Project Name: Unser & McMahon

April 13, 2021

**RE: UNSER/MCMAHON MIXED USE 10715 UNSER BLVD
EROSION AND SEDIMENT CONTROL PLAN
RESPONSE TO COMMENTS (A11E017)**

ENGINEER'S SEAL	UNSER & McMAHON
		Unser Blvd & McMahon Blvd
		EROSION CONTROL PLAN
		SHEET #
		ECP-1
		JOB #
		2020015

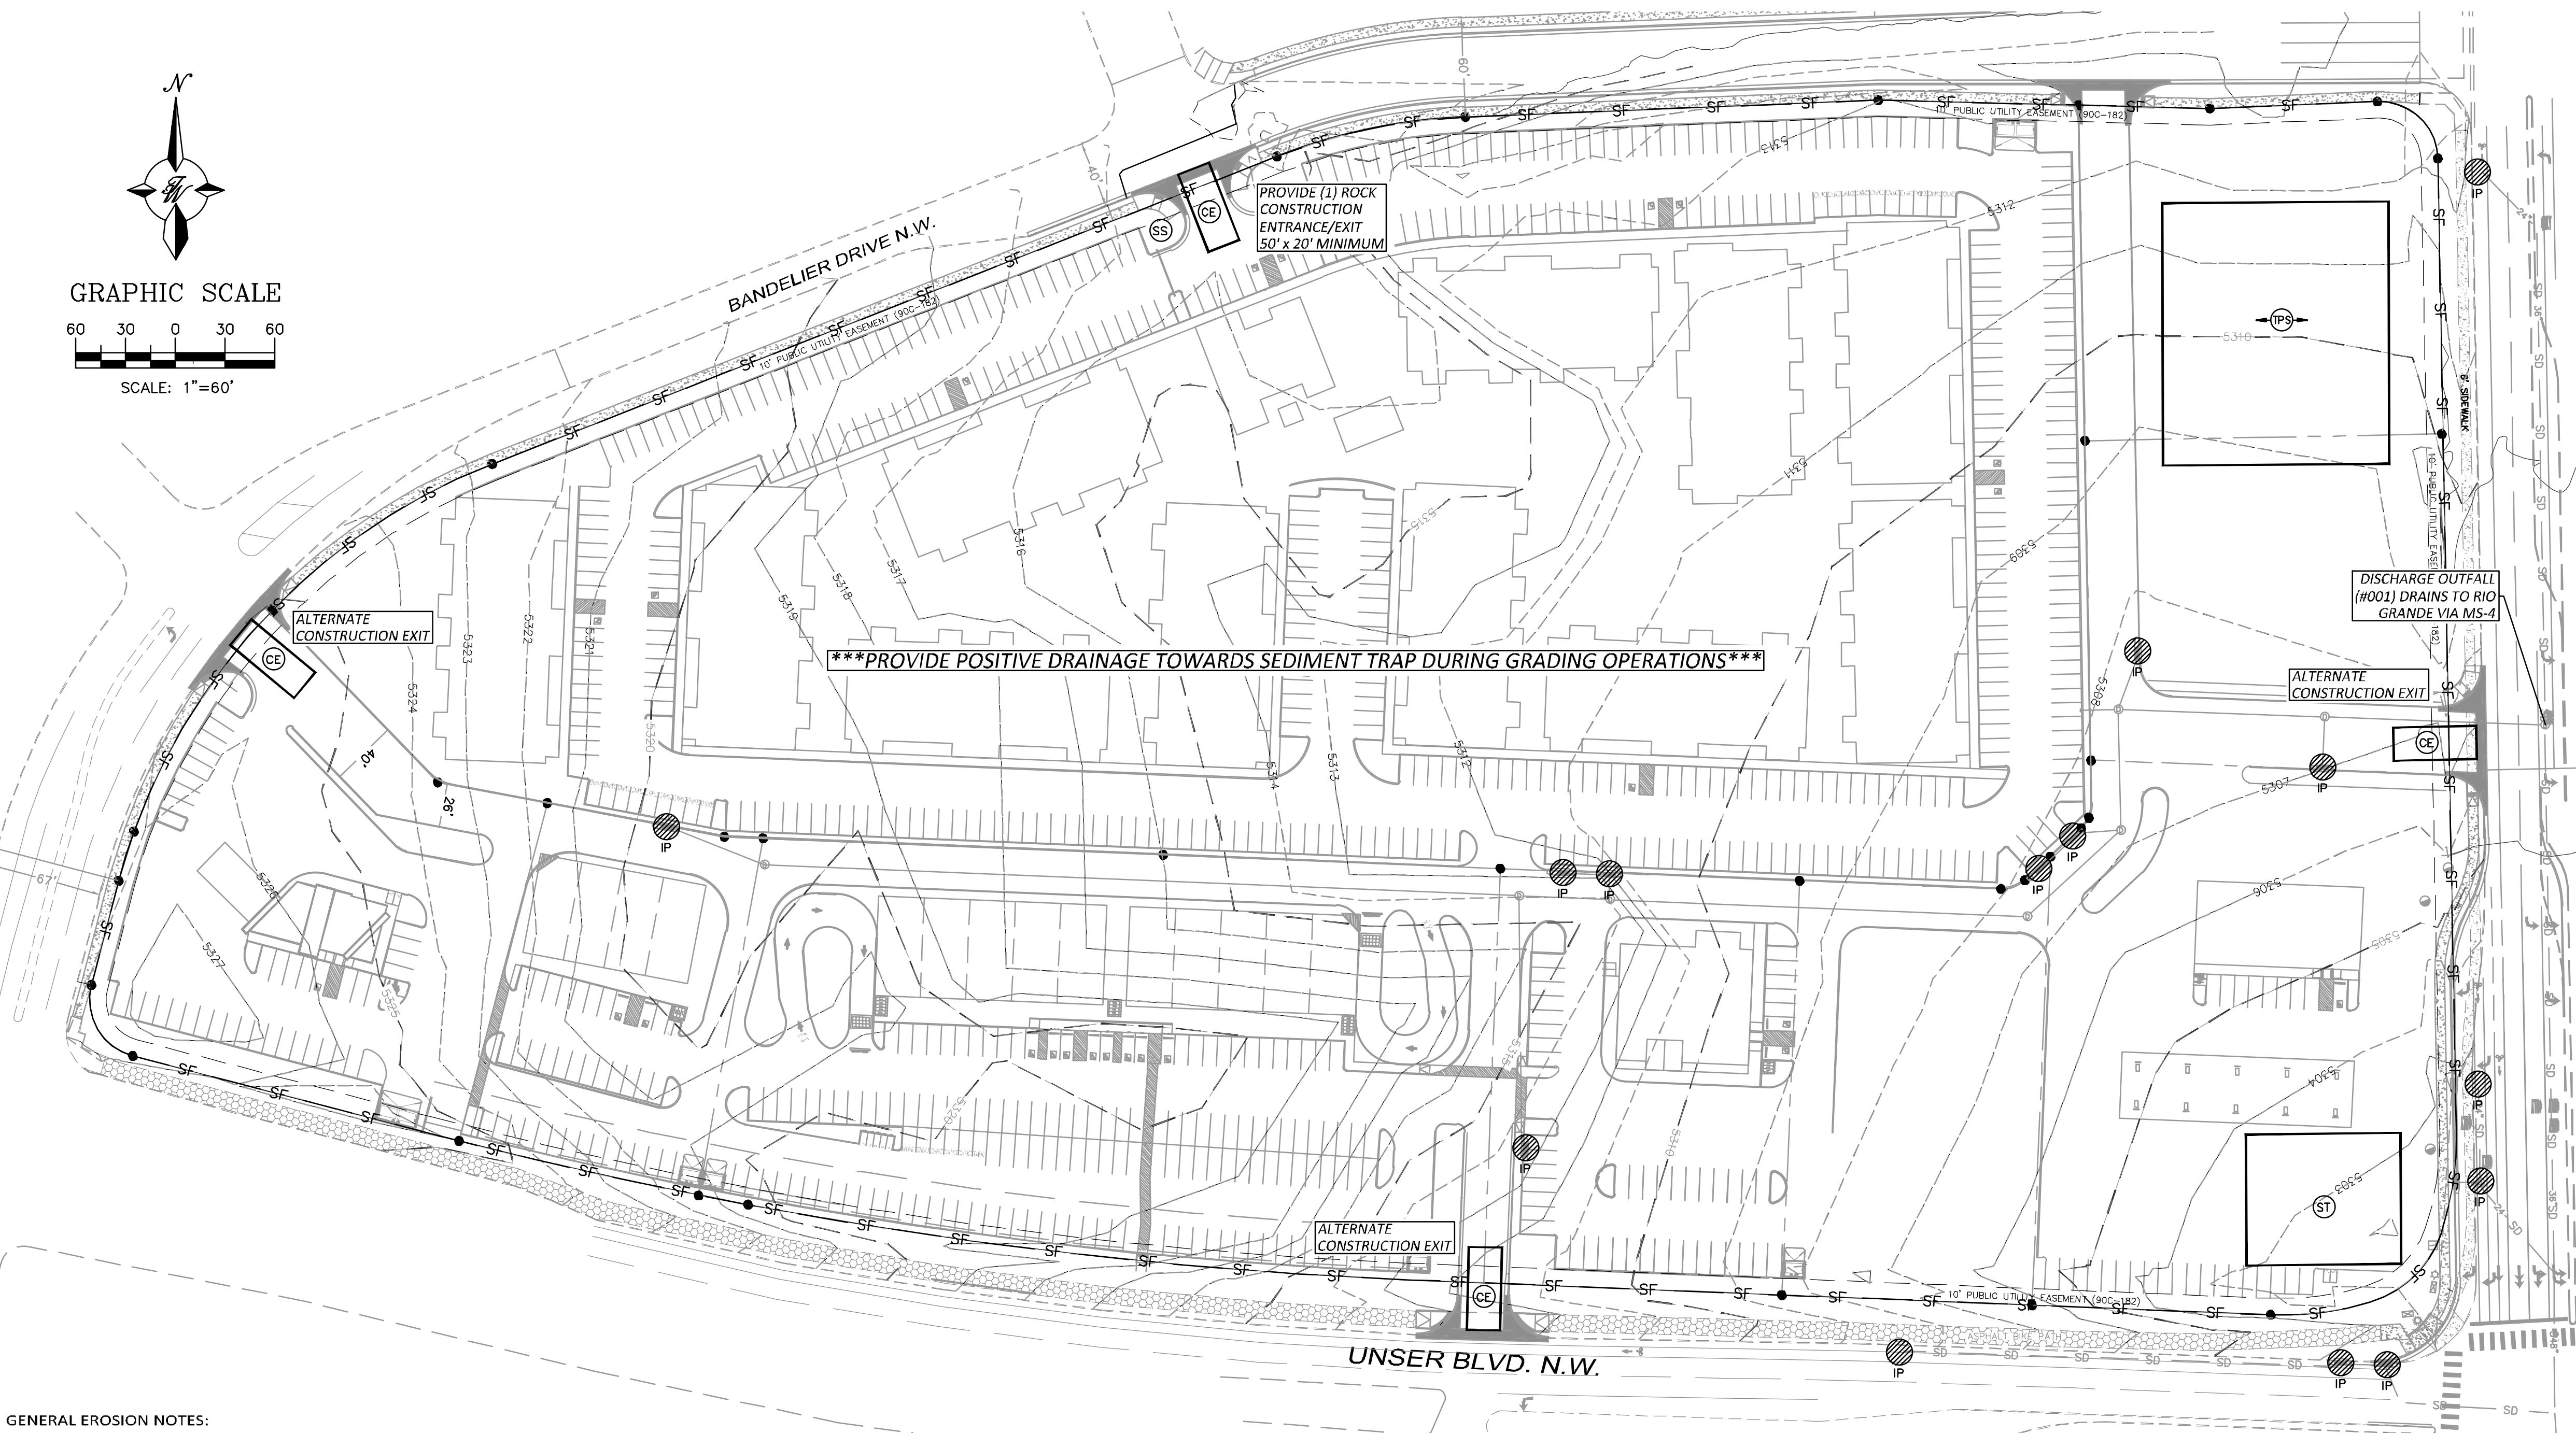
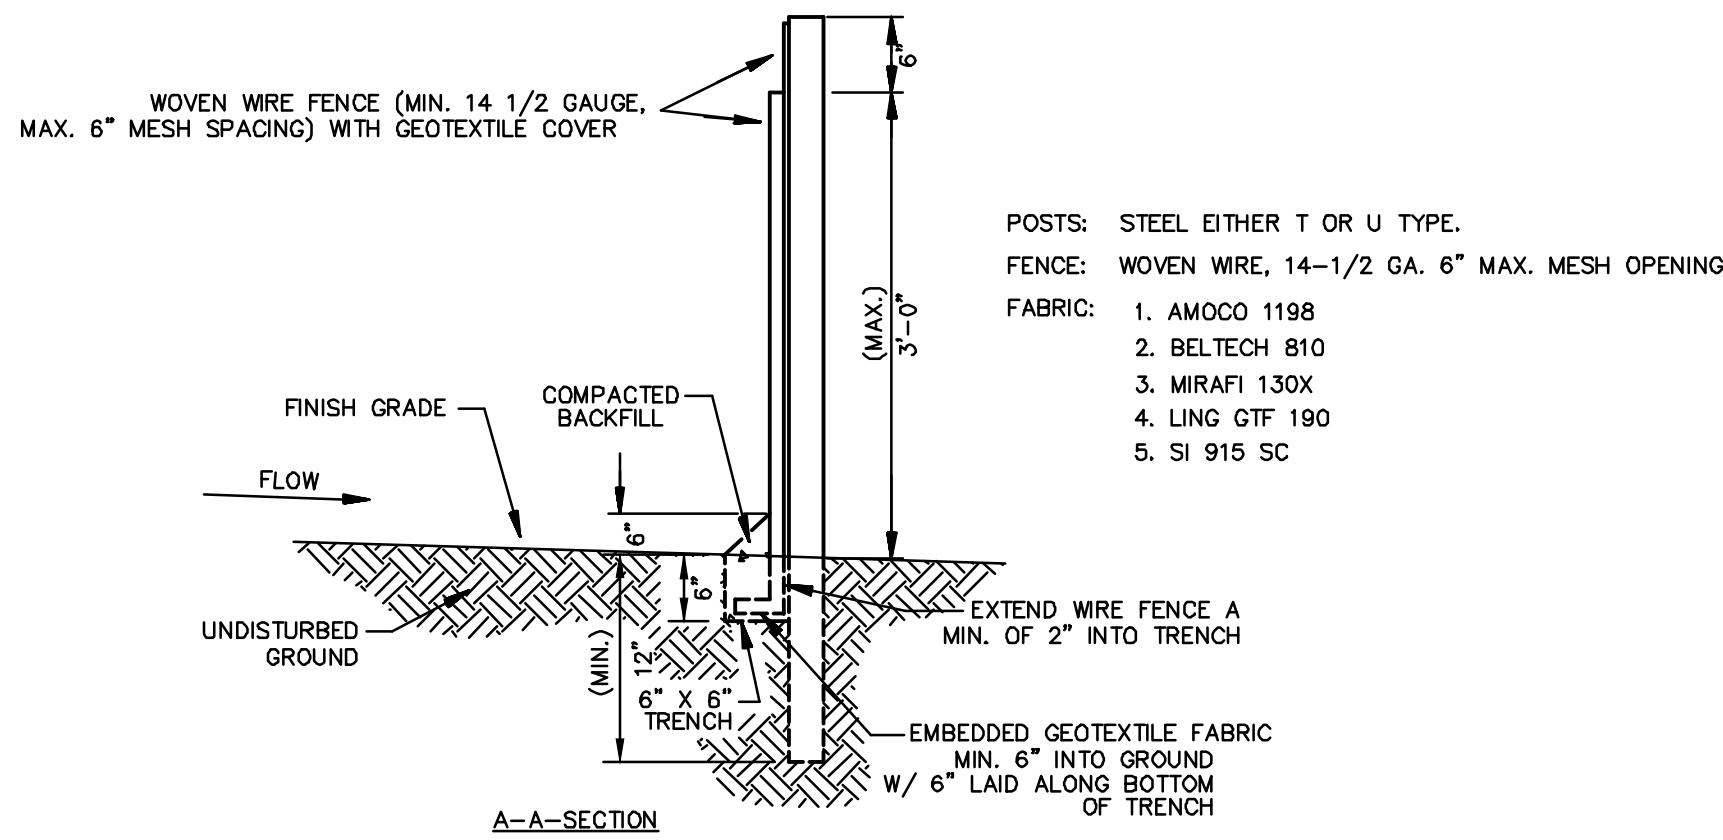
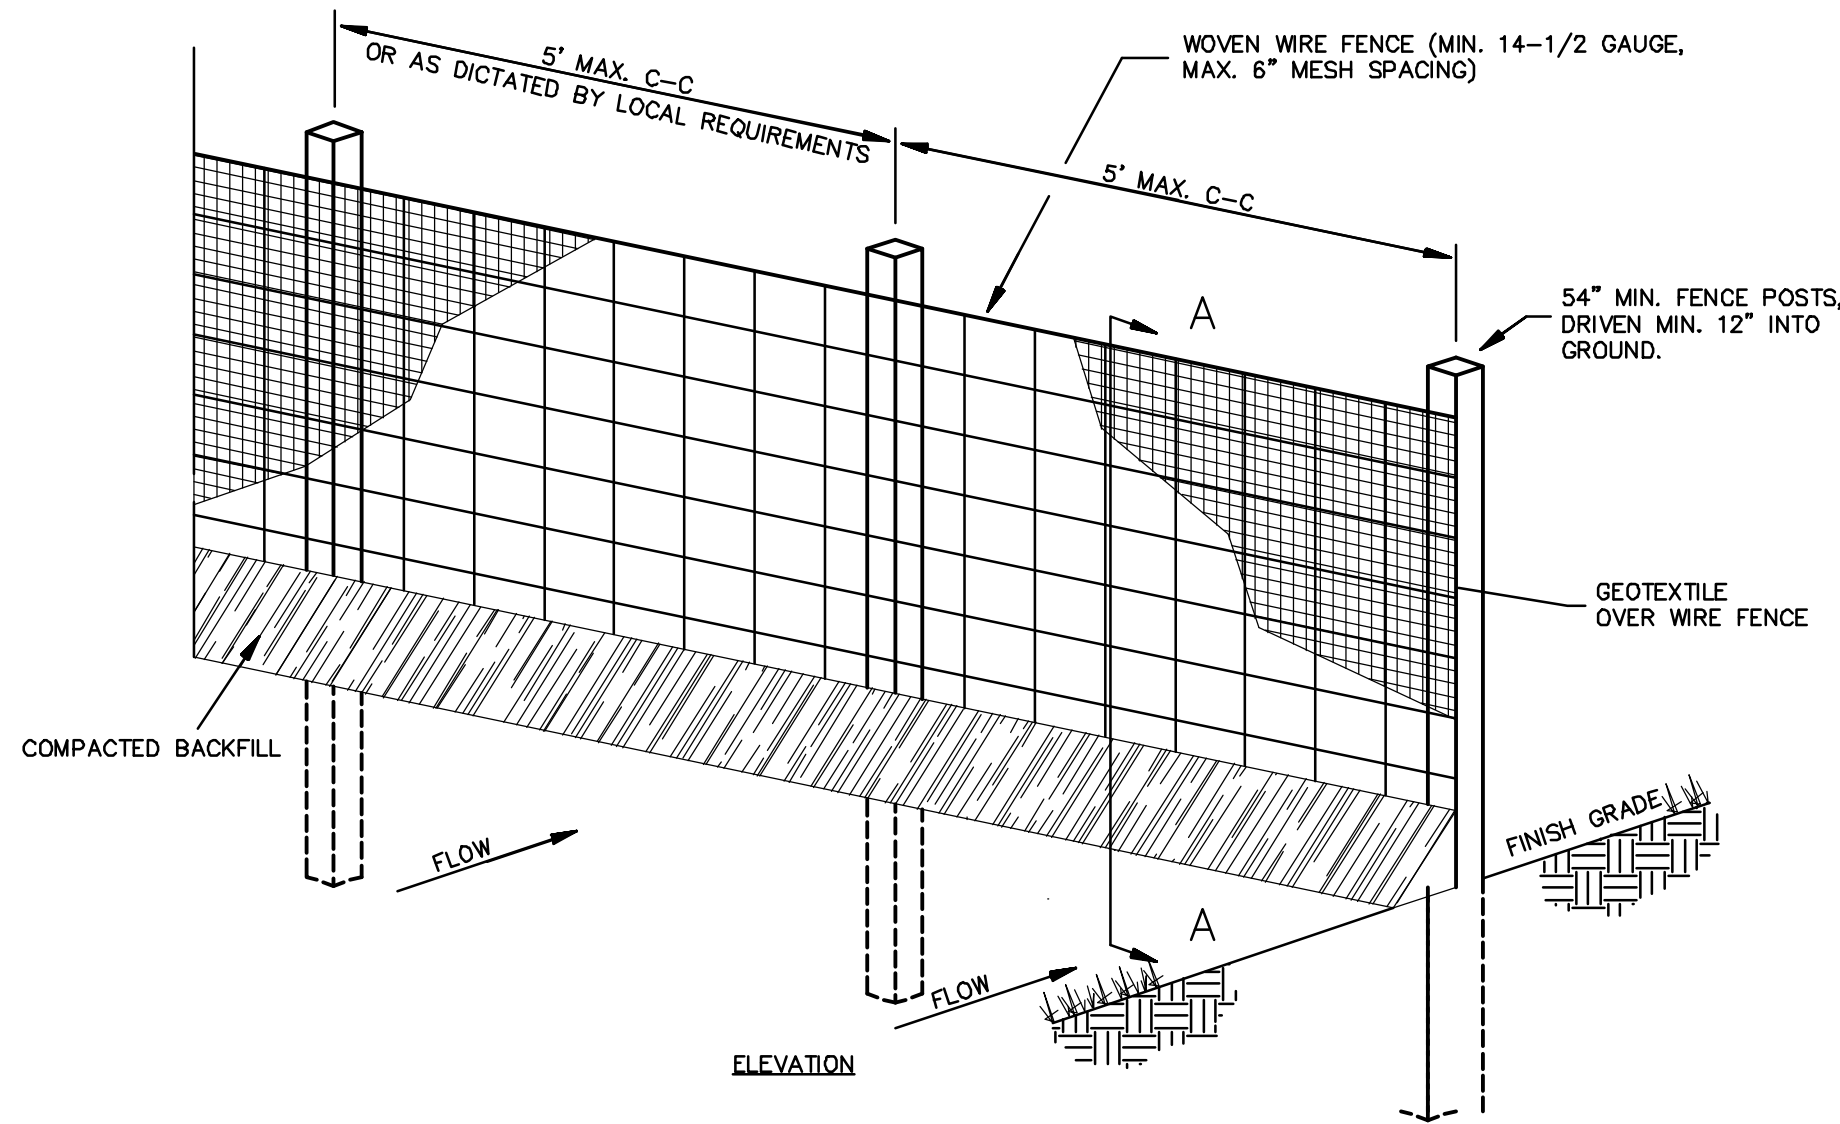
1. The north arrow is pointing west.
Response: The north arrow is now oriented in the correct direction.
2. The limits of disturbance must include all frontage improvements (CGP7.2.4.b.i).

3. The existing and proposed grades must be shown on the plan, and they must agree with the Grading Plan approved by Hydrology (CGP7.2.4.b.ii).
Response: The existing and proposed grades are now shown on the plan; the grades are the same as the approved Grading Plan stamped 08-04-20.

4. The locations of structures and other impervious surfaces. Differentiate between existing, construction this project, and future construction by others (CGP7.2.4.b.v).

5. Describe undisturbed and pre-construction ground cover (CGP7.2.4.e).
Response: The pre-construction ground cover description can now be found on the plan at the bottom of the Legend table. The ground cover described is undisturbed and uncompacted soil with native vegetation.

6. List operators on the plan, including name, phone #, and email address. If unknown, leave blanks to be filled in later (CGP7.2.1).
Response: Operators are unknown at this time, so a "List of Operators" to be filled out at a later date is now shown near the lower right corner of the plan.

7. Identify stormwater team members responsible for sediment removal, BMP maintenance, and inspections on the plan, including name, phone #, and email address. If unknown, leave blanks to be filled in later (CGP7.2.2).

8. Describe the nature and extent of construction activities (CGP7.2.2), including a) nature of construction activities, b) size of the property, c) size of disturbed area, d) description of construction support activities, e) size of maximum disturbed area, and f) project schedule. The three phases of this project are Grading, Infrastructure, and Sales. Provide a brief description of the nature of each phase. Include in the schedule the initial establishment of the sediment trap before the grading phase, the removal of the sediment trap and placement of additional silt fence to keep sediment out of the onsite street after the infrastructure phase, and the annual maintenance plan of the BMP's and stabilization practices (temporary and permanent) during the sales phase. Describe the expected circumstances of Termination of permit coverage including a final stabilization specification or sale and transfer to other operators. The operators and team members for each phase should be identified in 6 and 7 above.

9. Stabilization measures (CGP7.2.6.b.vi), including a) specific vegetative and non-vegetative practices, b) deadlines, c) beginning and ending dates of the seasonably dry period, d) procedure to comply with The Weed Removal Ordinance (§ 9-8-1) during sales phase:

10. Soil Information – add a table with name type, particle sizes, and erodibility factor (CGP2.1.1)

12. Vicinity Map – add a zone atlas map clearly indicating location and street names.

13. City Standard ESC Notes attached.

Response: The plans have been updated to show the limits of disturbance to include all frontage improvements. This includes 1) the driveway entrances off of Unser, McMahon, and Bandelier, 2) the Bandelier roadway extension to McMahon, and 3) the sidewalk along the existing Bandelier Road. Sidewalks and trails already exist along Unser and McMahon frontage so the limits of disturbance come up to the back of those walks.

Response: The plan has been updated to show only what is to be constructed in this project. The scope of work in this project includes mass grading, storm drain installation, paving of access road internal to site, and the frontage improvements as mentioned in comment response #2.

Response: Stormwater team members are unknown at this time, so a "Stormwater Team Members" section to be filled out a later date is now shown near the lower right corner of the plan.

Response: A "Nature and Extent of Construction Activities" notes section has been added to the plan to include all of this information. This would include, nature of construction activities, property size, disturbed area size, description of construction support activities, max disturbed area, project schedule, grading phases, infrastructure phase, sales phase, annual inspections, NOT termination, stabilization measures, and City Weed Removal Ordinance. A BMP maintenance notes section is also shown on this plan sheet.

Response: The added "Nature and Extent of Construction Activities" notes section on this sheet includes the stabilization measures.

Response: A soil information table has been added to the lower right corner of the plan identifying this soil information.

Response: Vicinity/zone atlas map has been added to the upper right corner of the plan.

Response: The city standard ESC notes have been added to the lower left corner of the plan.
